SOUTH HOLLAND DISTRICT COUNCIL

To: Planning Committee - 07 June 2023

Purpose: To consider Planning Application H16-0042-23

Description: Change of use of a residential property (C3) to a HMO (C4 or Sui Generis) - re-submission of H16-0737-22

STONEGATE
10 CARS

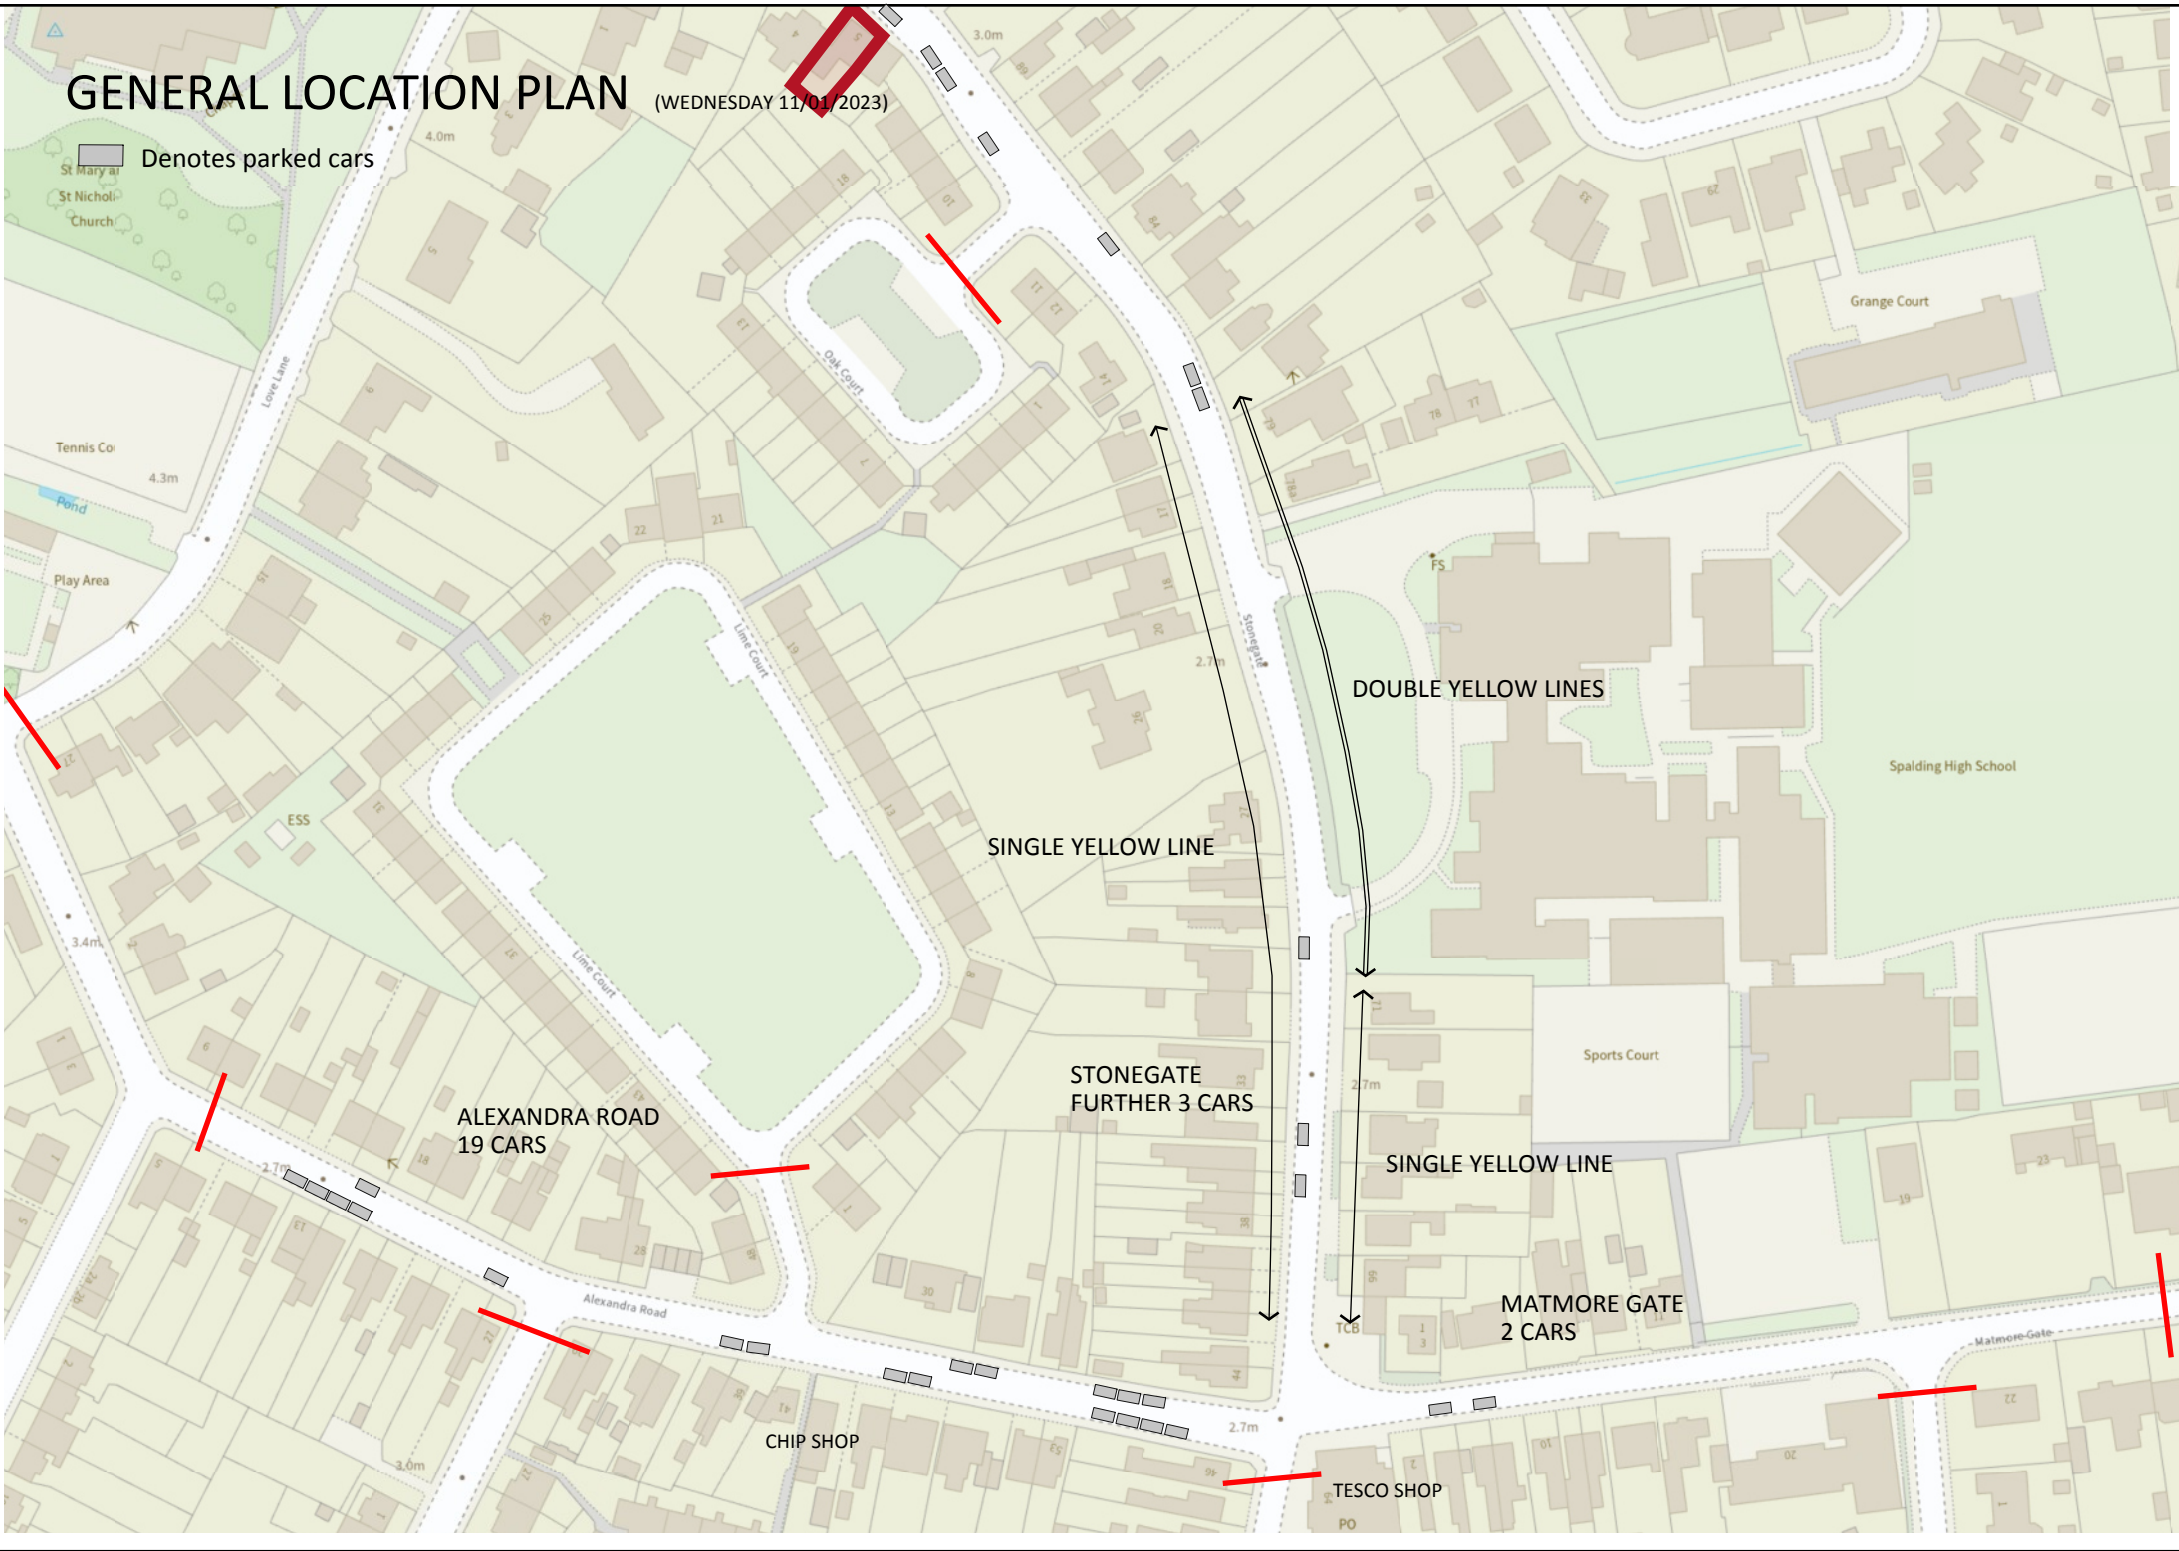
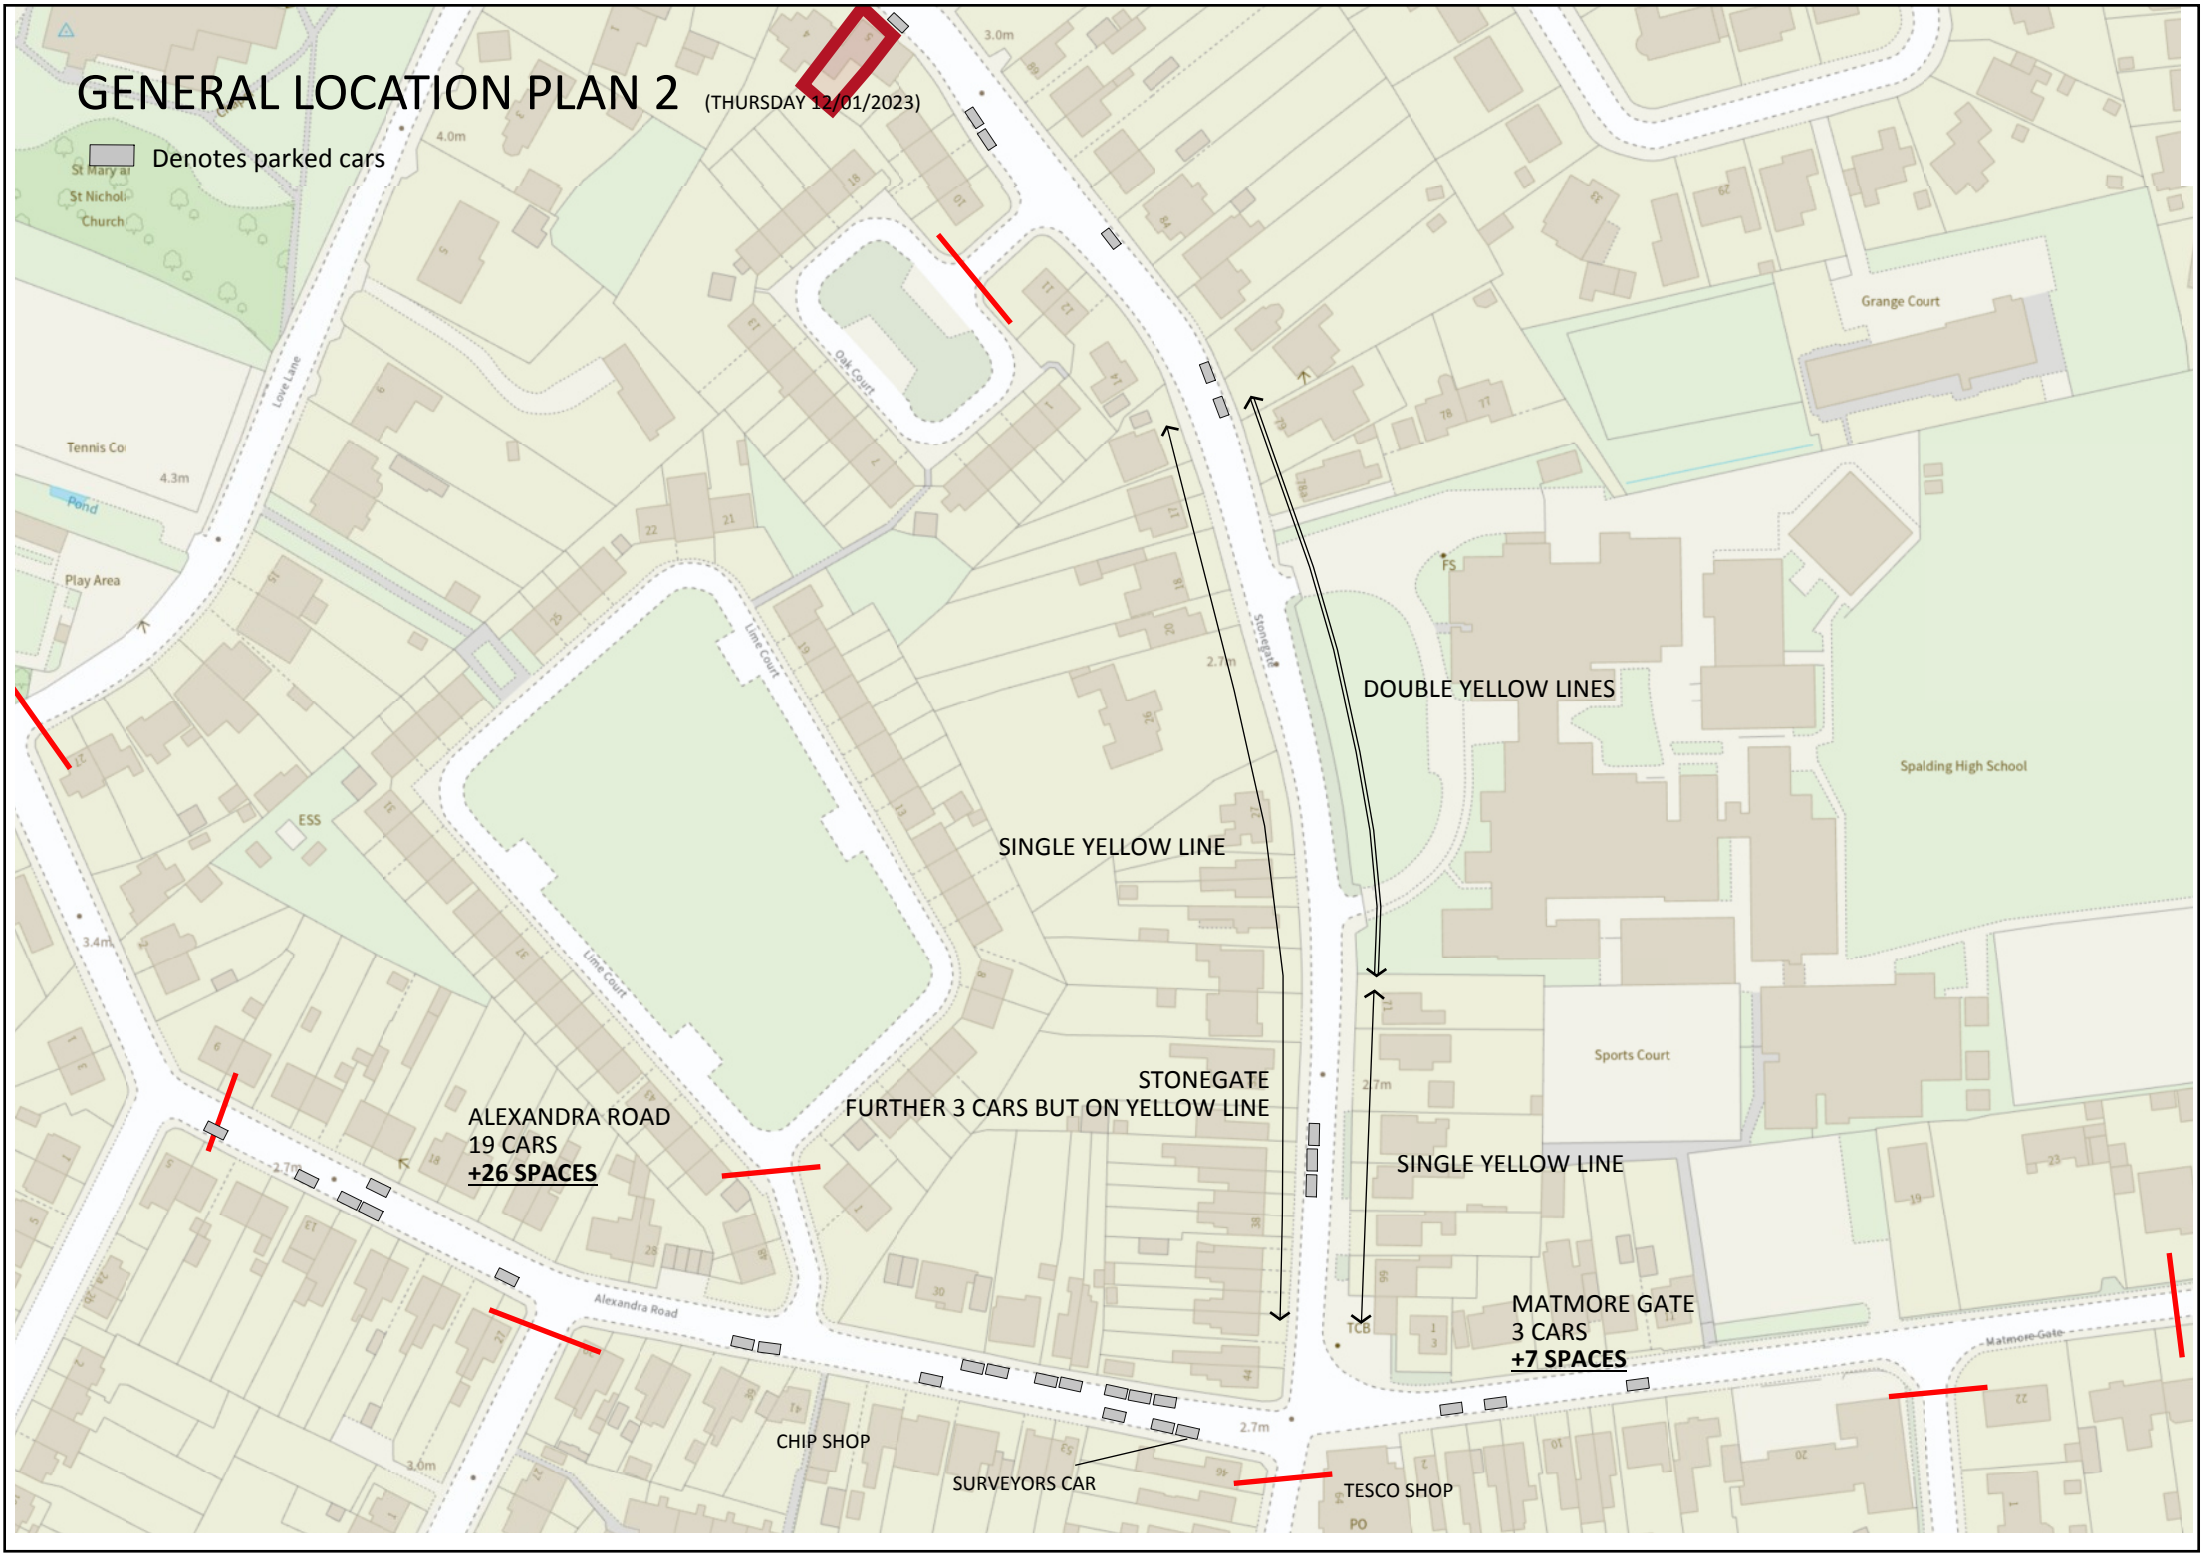
However, it is accepted that there is the possibility that not all future residents would have access to a private or personal vehicle or wish to have this access and the site, in its current form and lawful use, has the future potential for six occupants that each may have individual access to a vehicle. Furthermore, the Local Plan does not specify defined parking standards relating to HMOs. The submission has been accompanied by a parking survey, which was undertaken to illustrate the availability of parking spaces. This survey assessed the parking that was available within a 500m radius of the property, providing a suitable distance for walking to and from the property. The accompanying Design and Access Statement details that the survey

shows a total of 134 spaces being available within 500m of the site on the date of the survey, with in excess of 71 spaces available within a 300m radius of the site; therefore, indicating adequate parking availability within close proximity to the site.

title
PROPOSED SITE PLAN

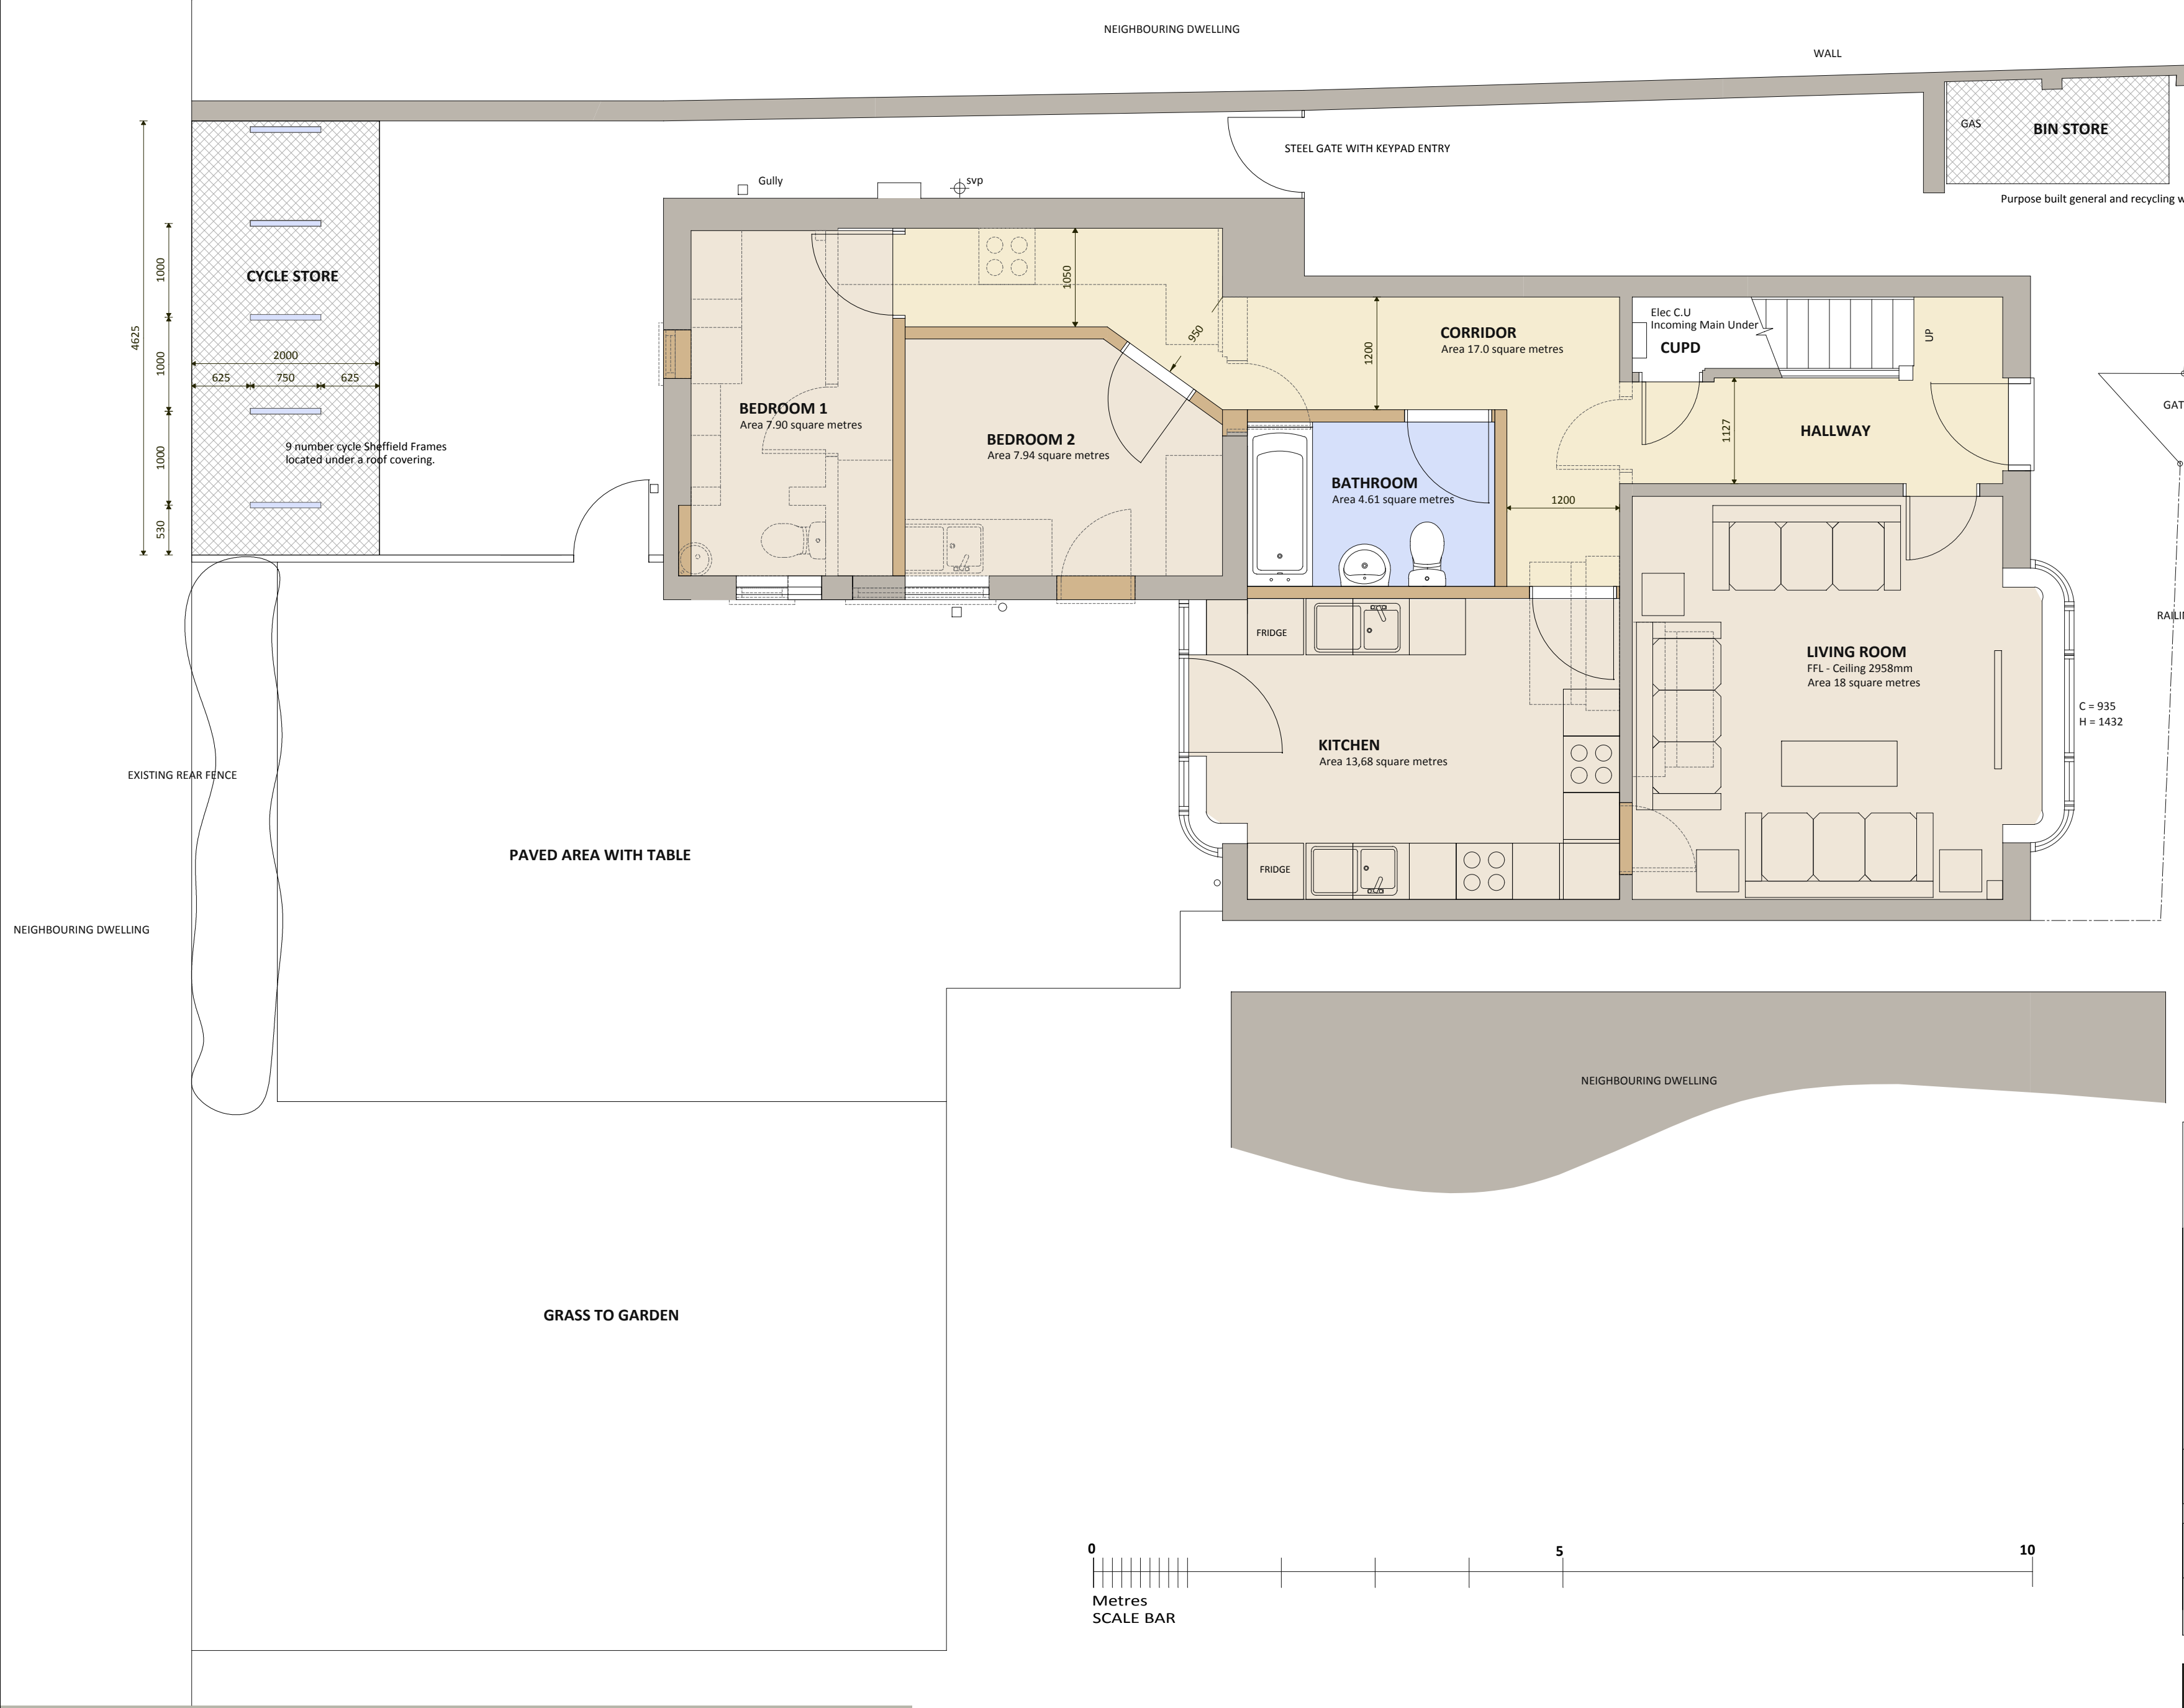
7.10 4. Concerns were raised by the public over the increase in household waste and that it could be poorly managed. Given the volume of refuse likely to be generated from the property, it is considered that the allocated communal bin storage behind the railings would be adequate enough for the additional number of occupants. The proposal is considered to accord with this criterion. This consideration differs from the previous refusal reason and is also very much on balance. Whilst the previous case officer was of the view this was unacceptable, it did not form part of the refusal reason.

- 7.12 6. As highlighted above, the site has good access - by walking and cycling - to community facilities, services, public transport and local employment. There is also the provision of a 9 bike cycle shed to the rear garden of the property, which further promotes the use of active travel methods. The proposal is considered therefore, to accord with this criterion.

- 7.14 8. As shown on the submitted floor plans, there is an adequately sized communal garden and amenity area to the rear of the property. As such, this criterion is considered to be satisfied.
